Reference: Engineering Services  
88 Thunder Valley Ct.  
Harnett County, NC  
Project No.: 2101-020094

As requested by the client, a representative of Tyndall Engineering & Design, PA (TE&D) has reviewed and analyzed the following project items:

- 1) Recommend a repair for the proposed footing to accommodate the “stump hole” that was encountered within the existing rear wall footing excavation.

STEM WALL SLAB PLAN
Carter III

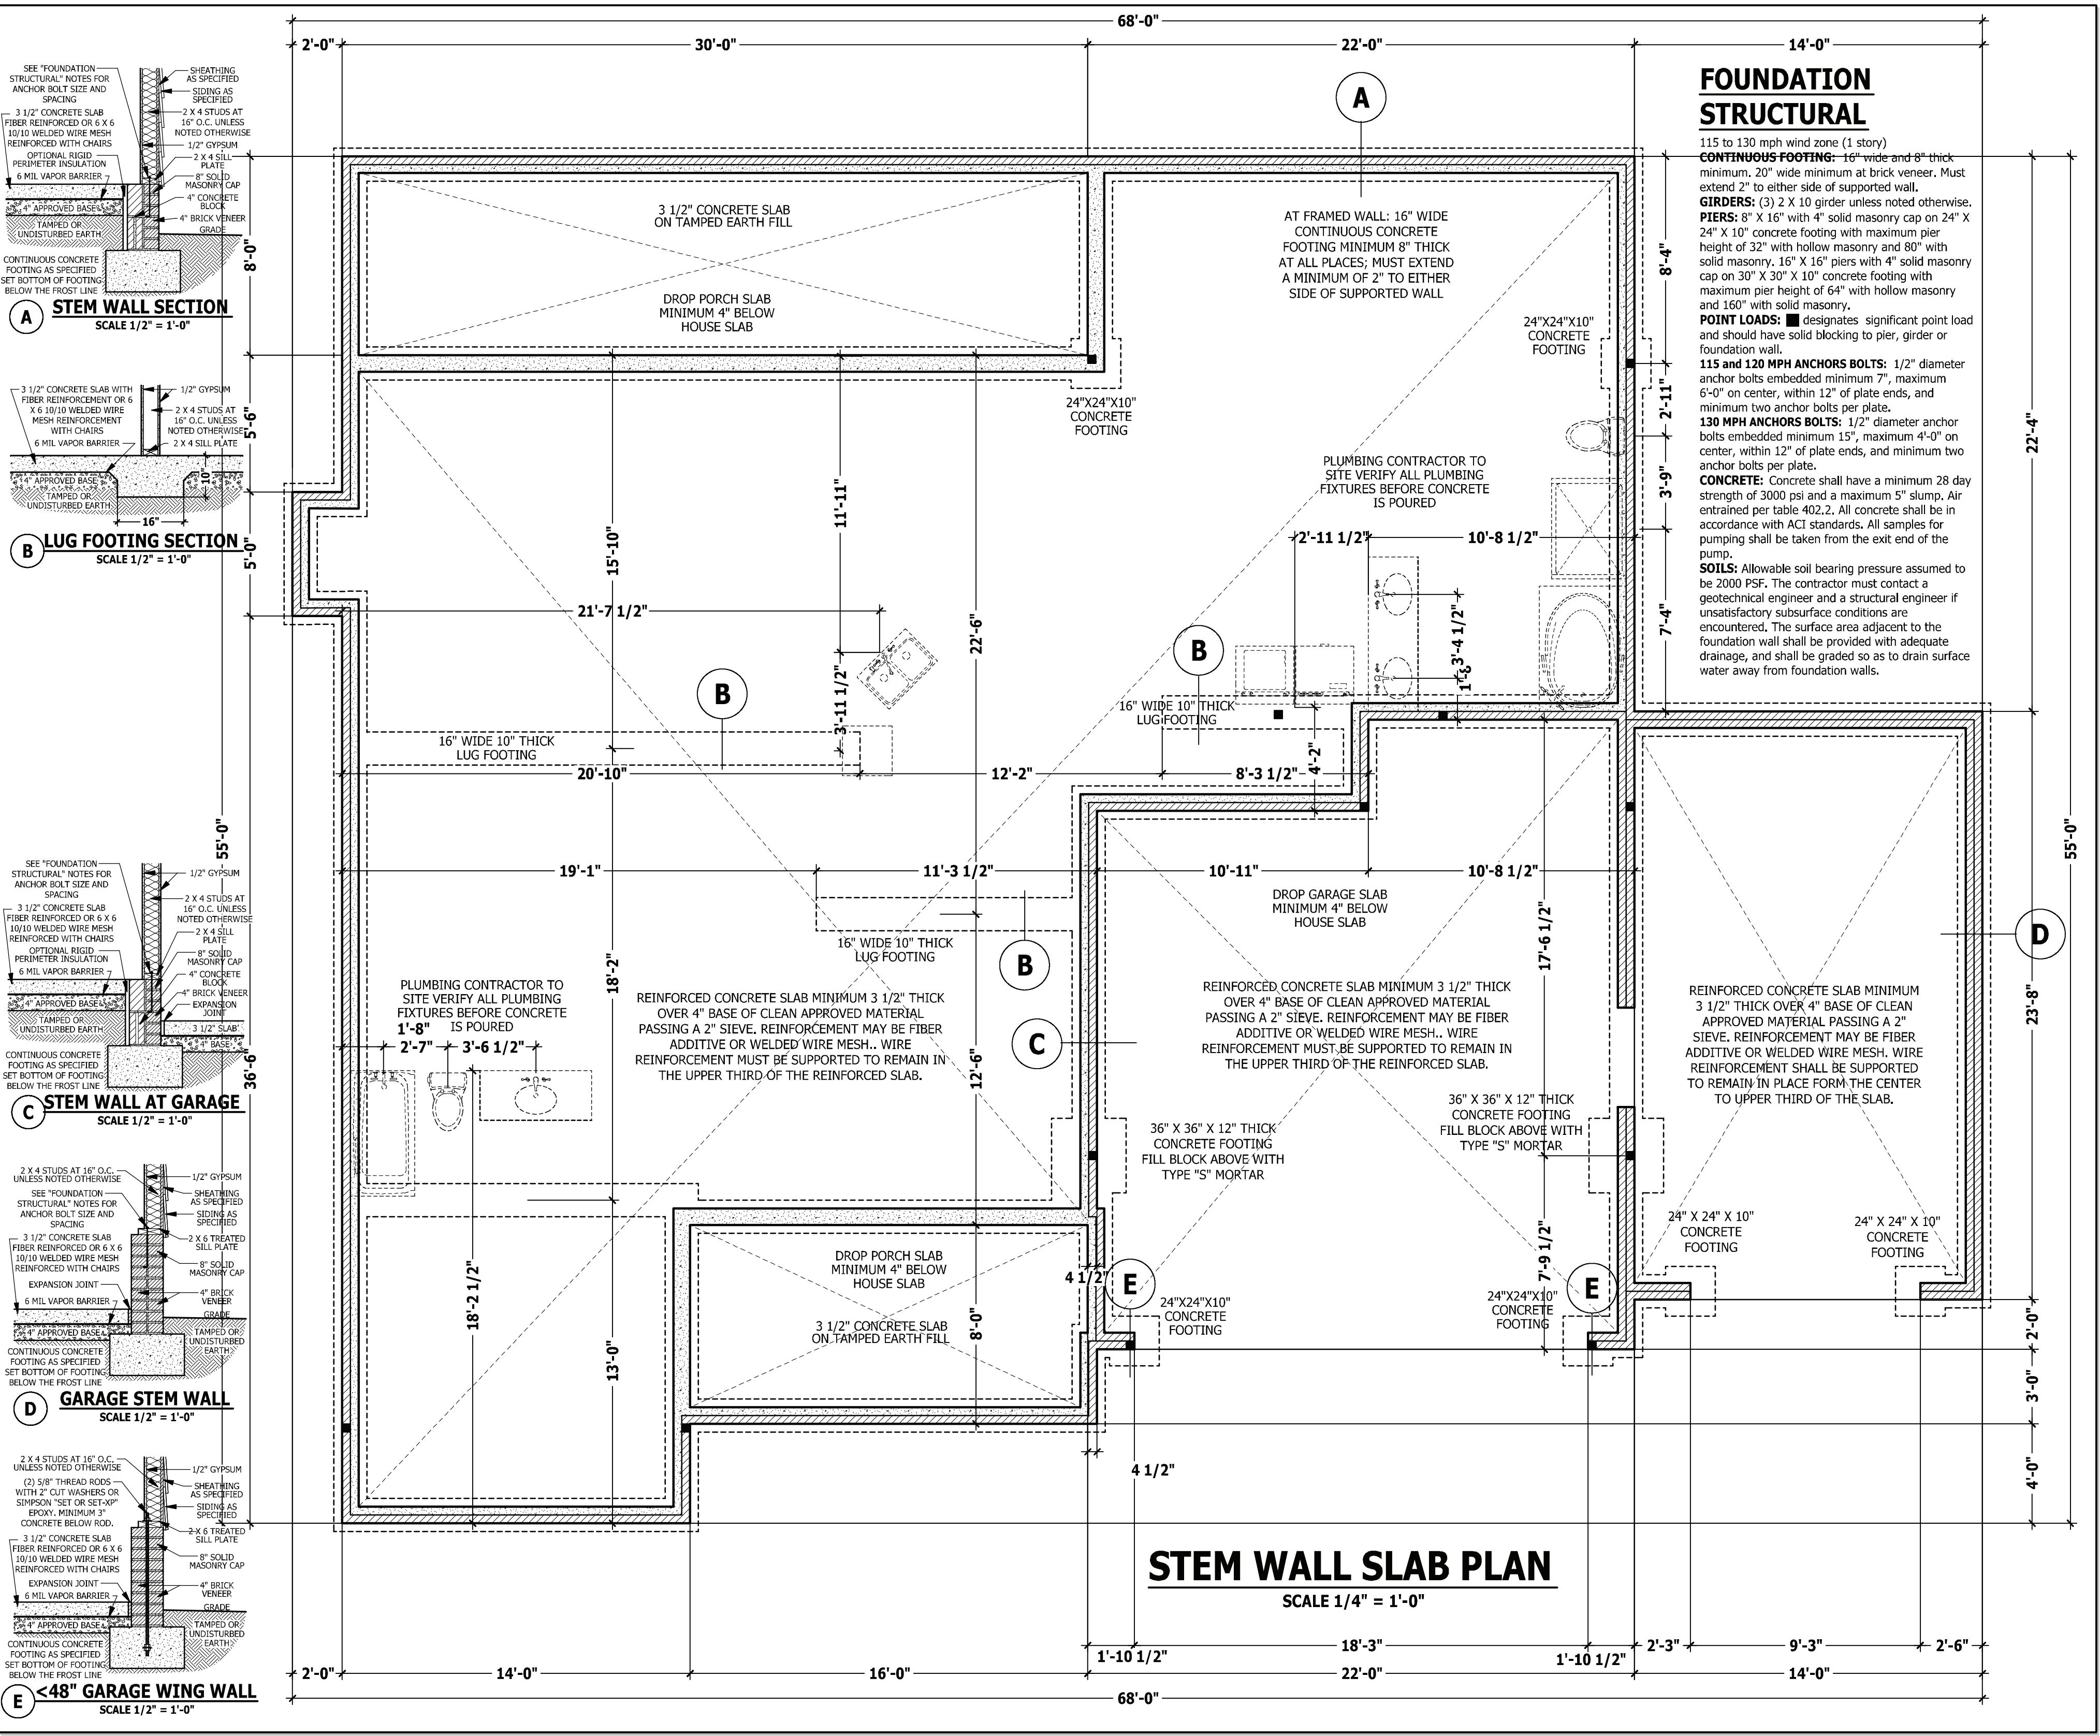
- 1) Based on our conversations with the contractor and supplemental analyses, it was recommended that the section of footing containing the “stump hole” be reinforced with (2) #4 rebars. The reader is referred to the photograph below. The existing stump excavation will be backfilled with additional concrete. These recommended repairs/enhancements will be structurally adequate to support the anticipated loading conditions.
